Erection of a traditional helter skelter

Butlins Skyline Ltd Upper Bognor Road Bognor Regis West Sussex

Thank you for your internet representation made on 15th May 2013 which has been recorded as '**an objection**' with the comments as follows:

drawing information title: Existing Site Location Plan

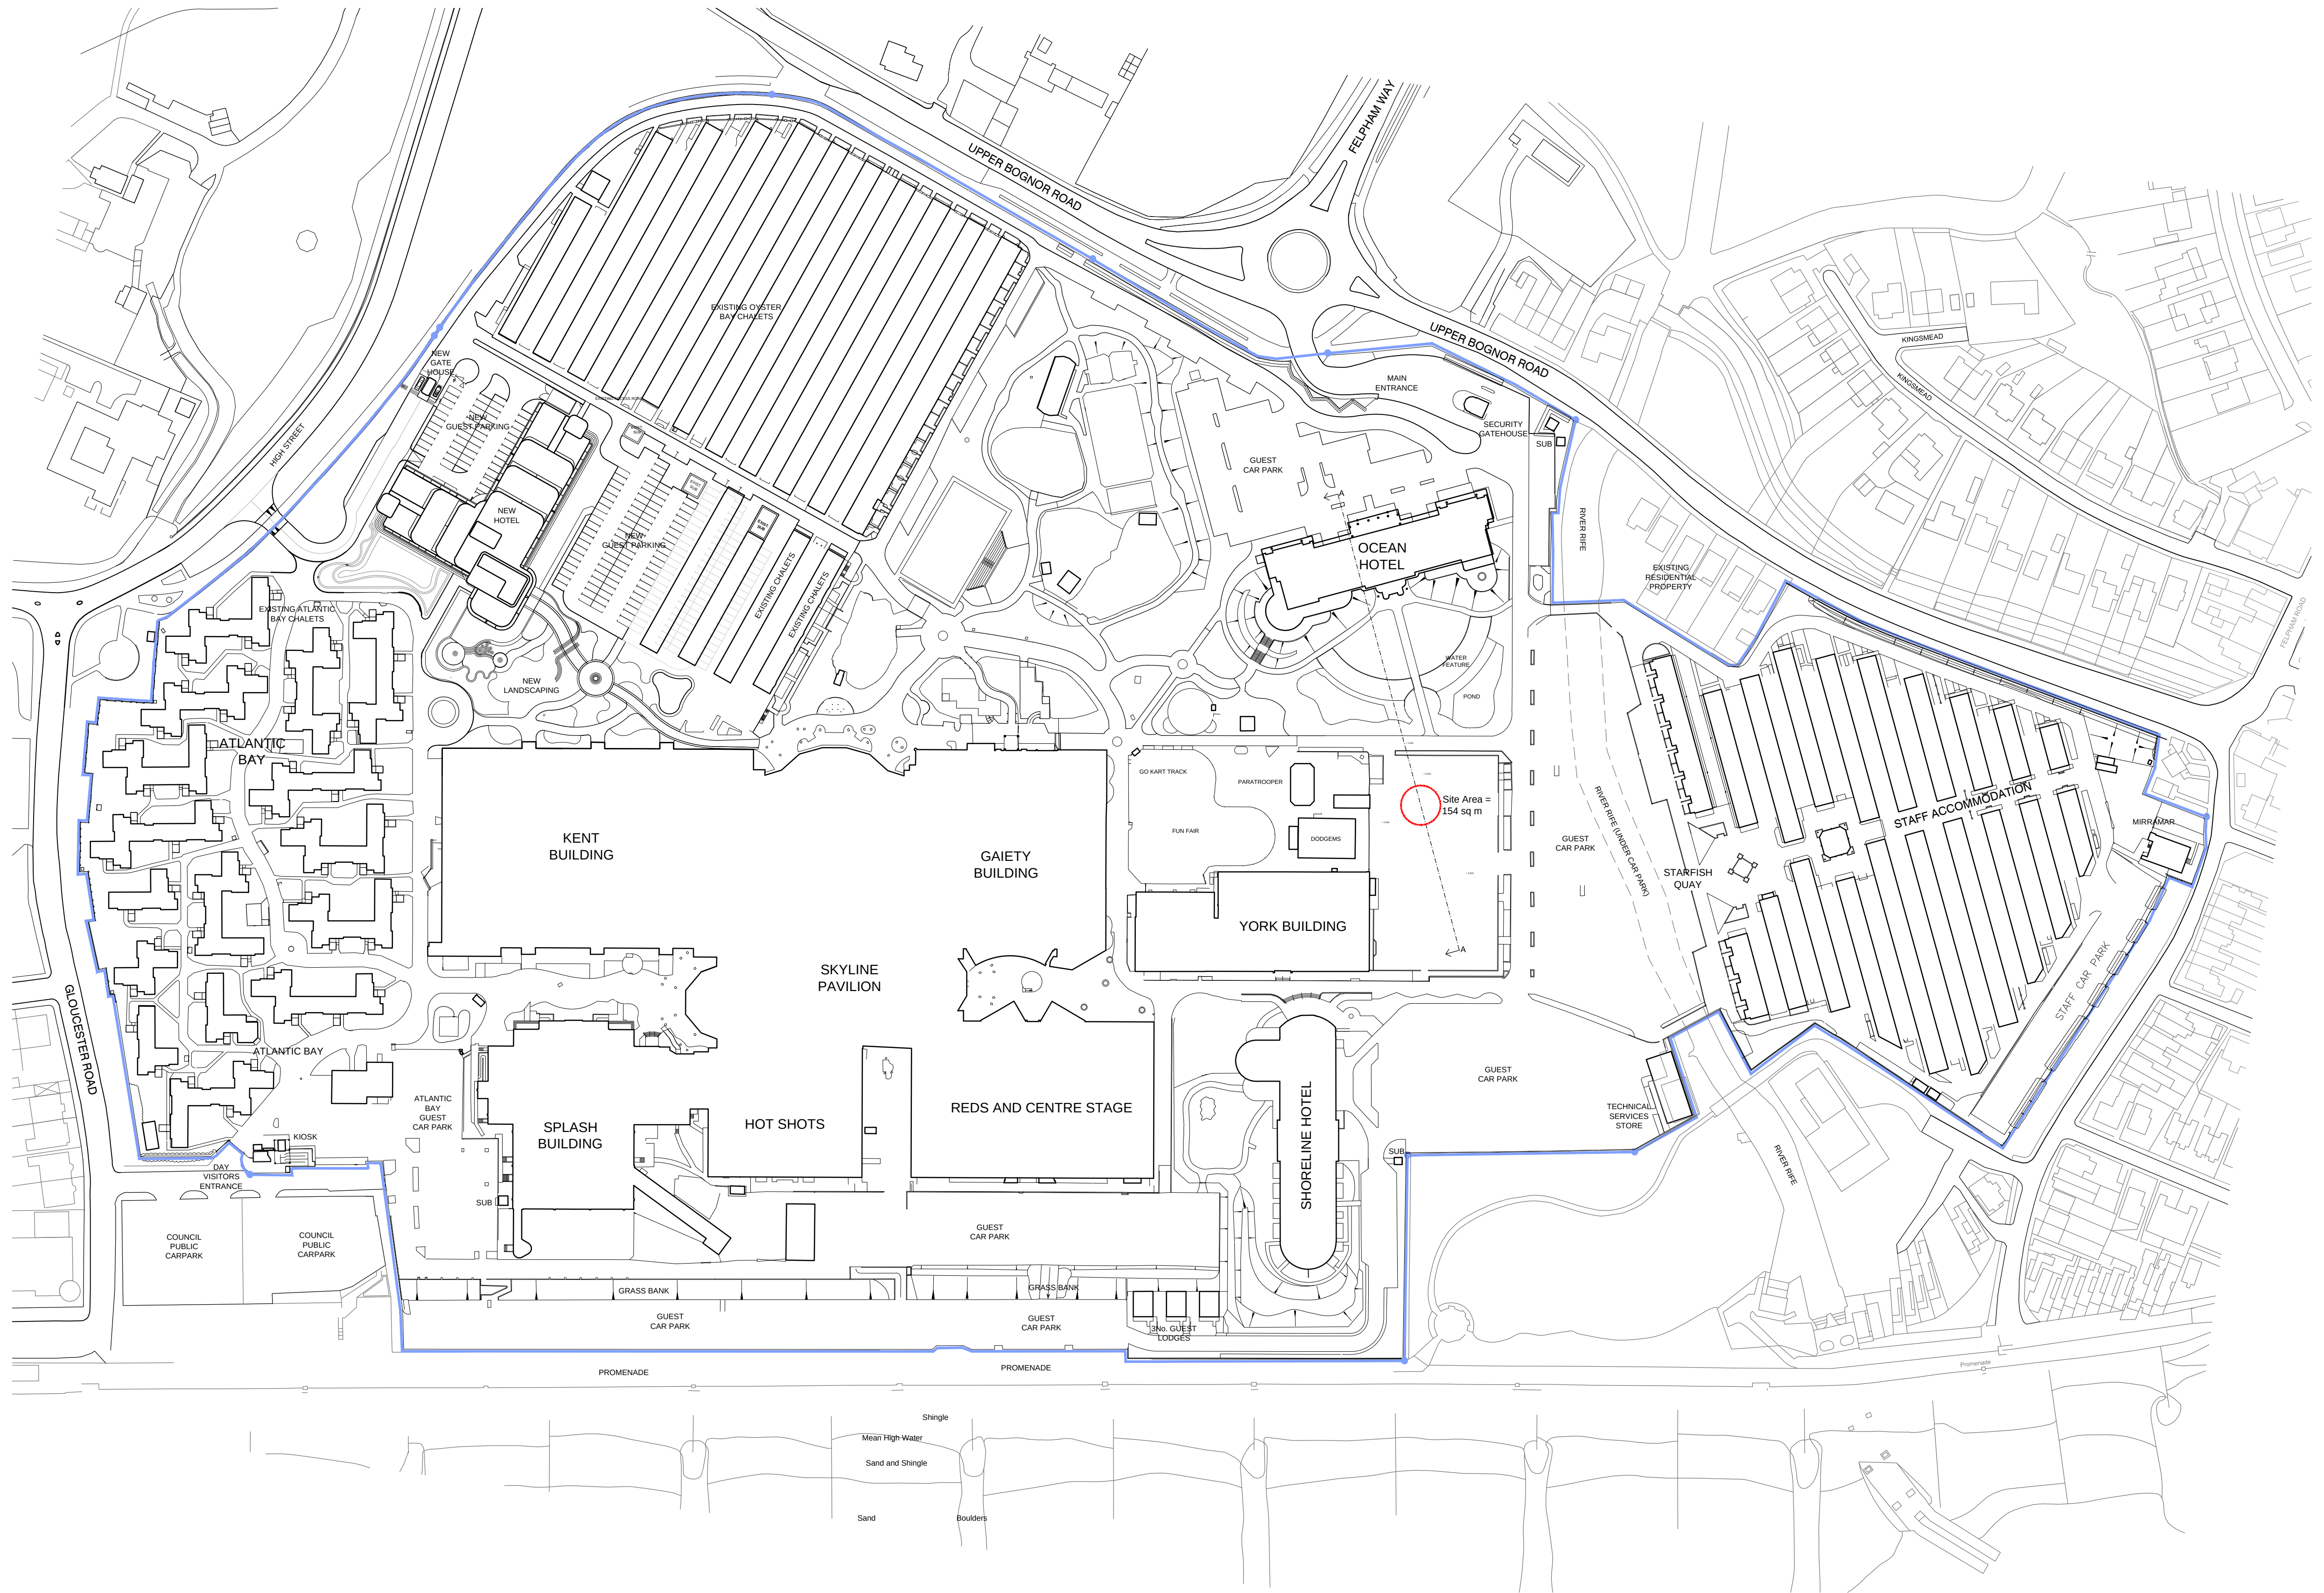
- *Moving closer to the Eastern boundaries and so nearer to Sea Road in Felpham.*
- *Noise pollution has increased.*
- *Already installed without planning permission.*
- *Increased light pollution to nearby houses.*
- *Takes up existing car parking space and car parking space is currently inadequate for the use of the site.*
- *The Committee believes the Helter Skelter exceeds the permitted height.*
- *It is 'encouraging' other rides to be erected.*
